Our Ref: WA/57/19/PL

**Town & Country Planning Act 1990 (as amended)
Town and Country Planning (Development Management Procedure) (England) Order 2015
Application for Planning Permission**

Development Rear Extension
Location Black Horse Inn Binsted Lane Arundel

REVISIONS

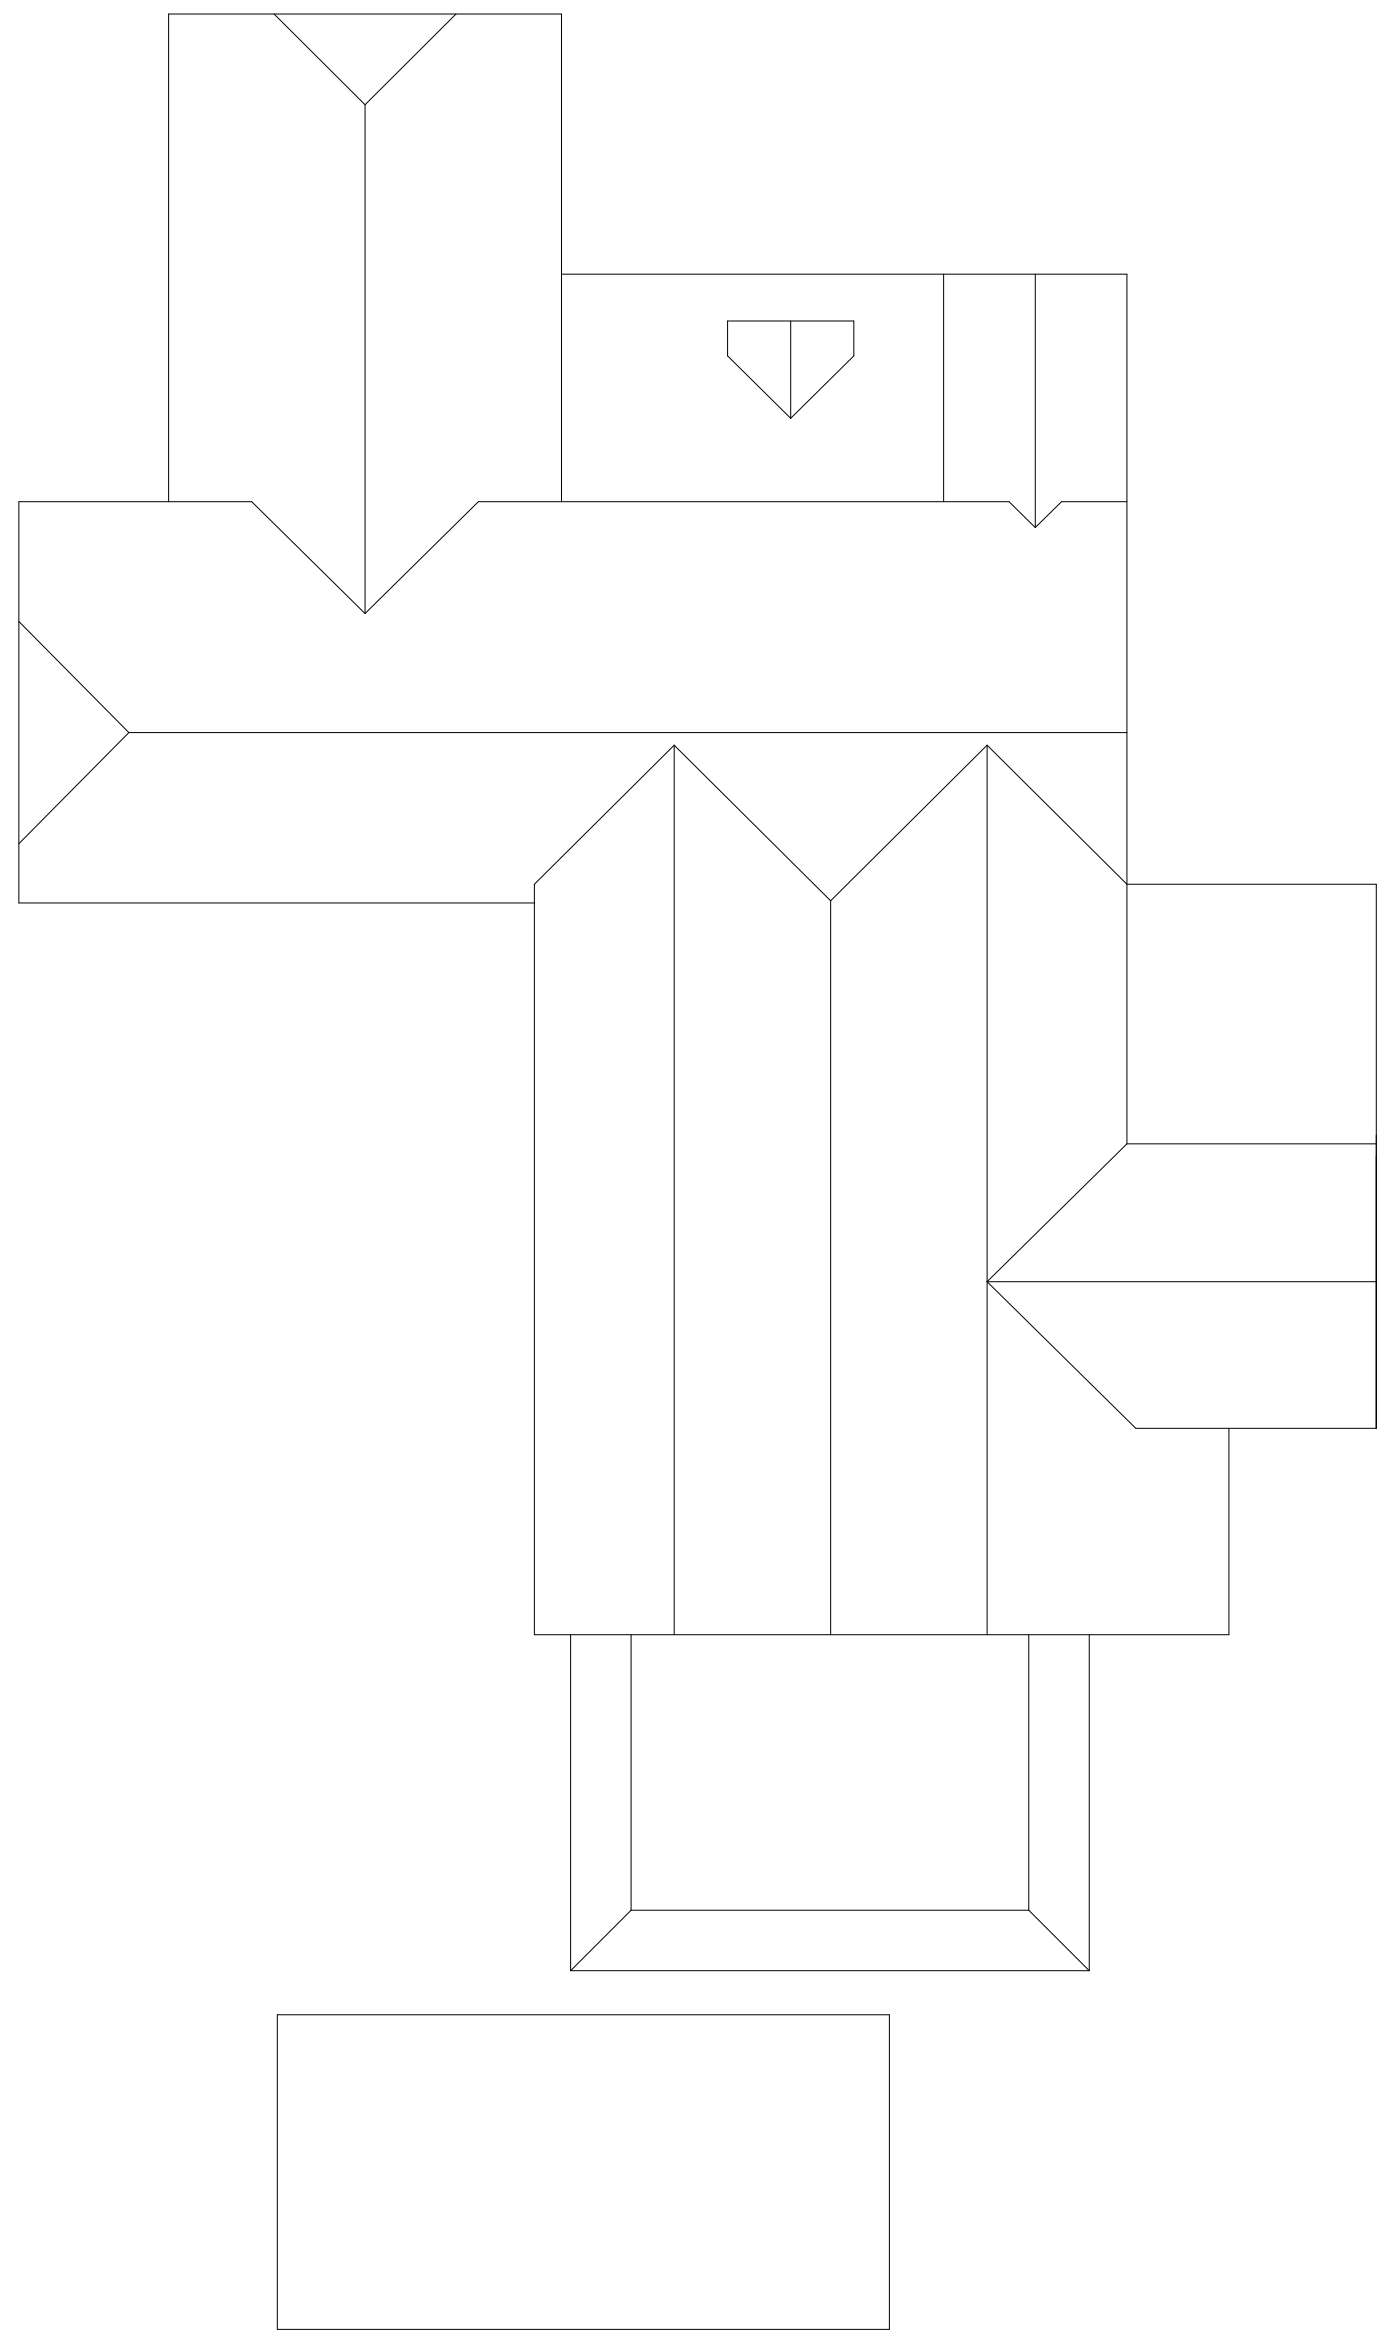
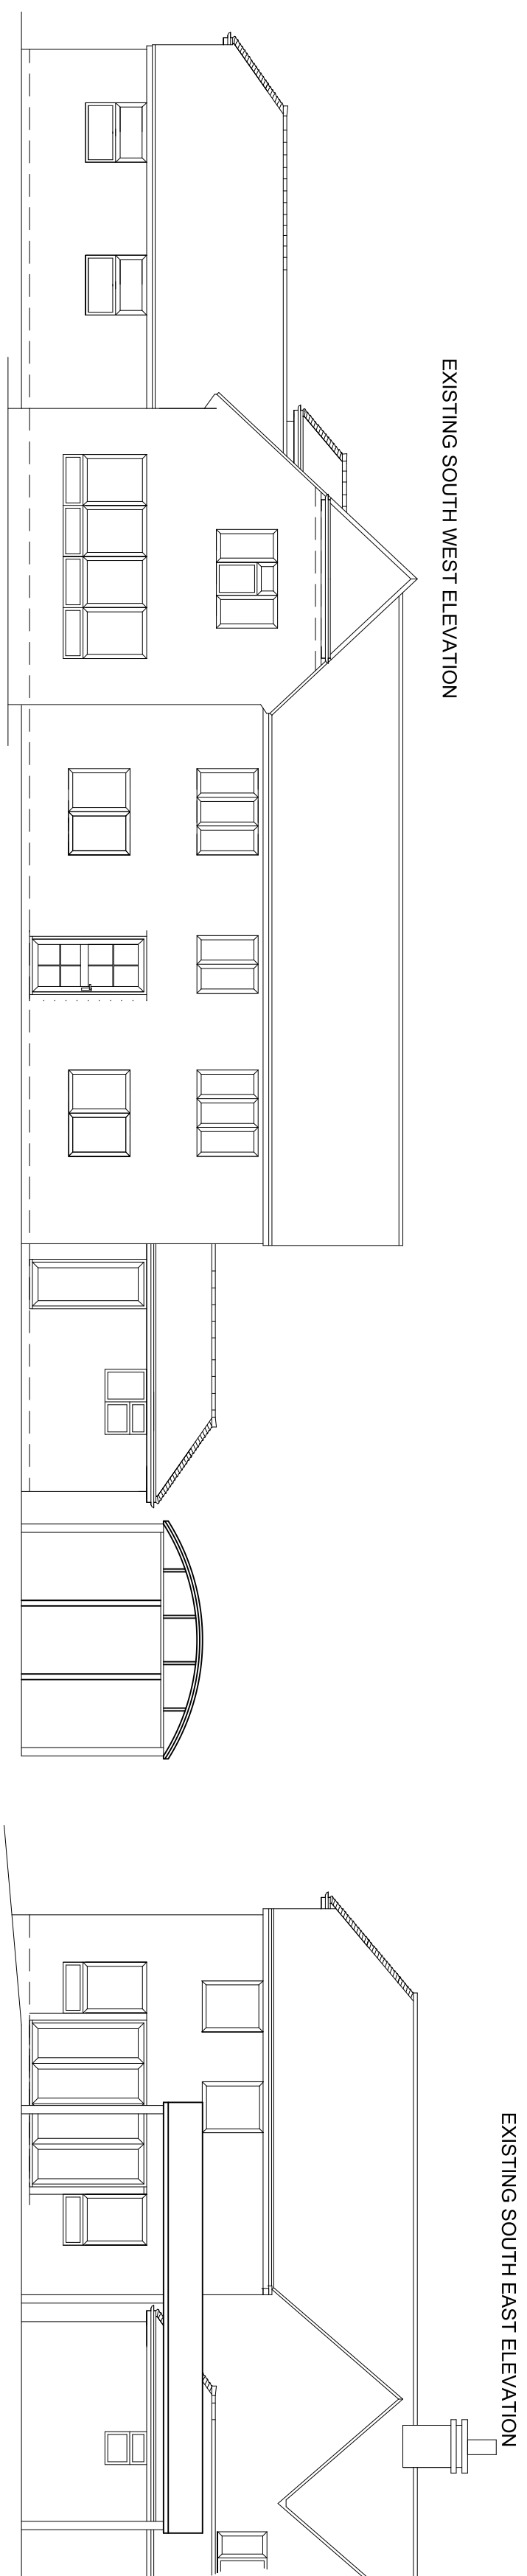
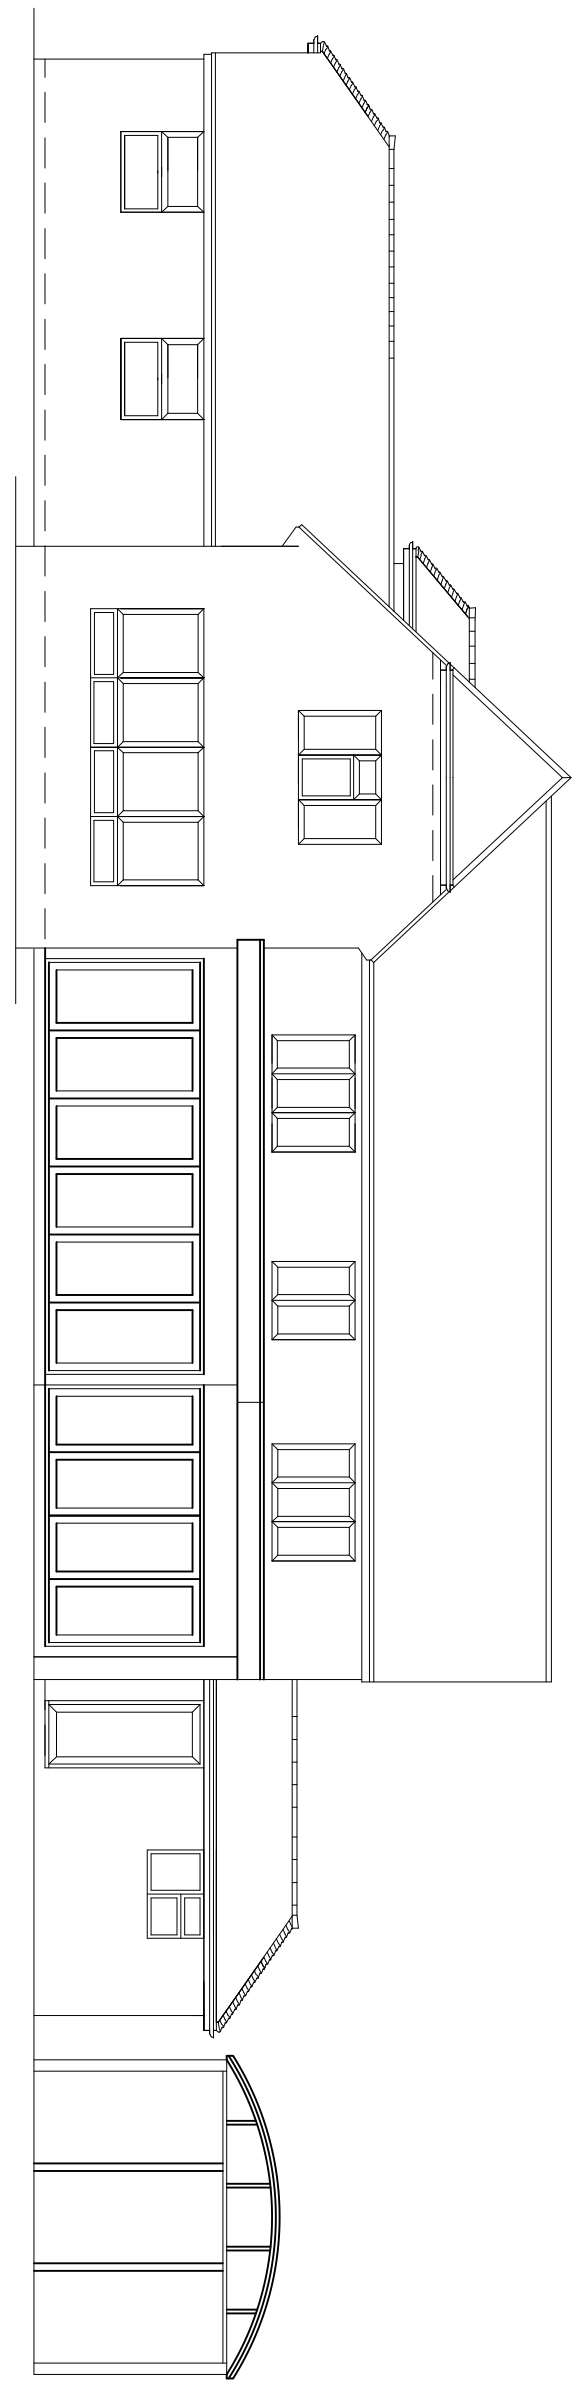
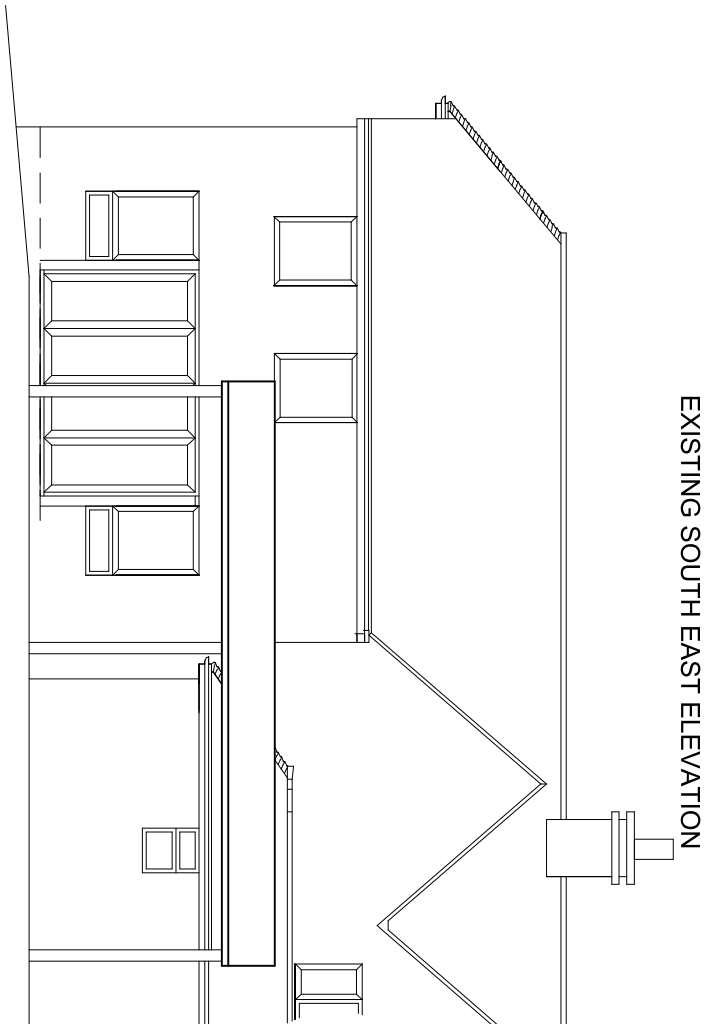
Confirmation Required: Please confirm whether you are applying for the HVAC unit under this application if so it will need to be included in the description with your permission we can include it in your description. If it is not it will need to be removed from your plans.
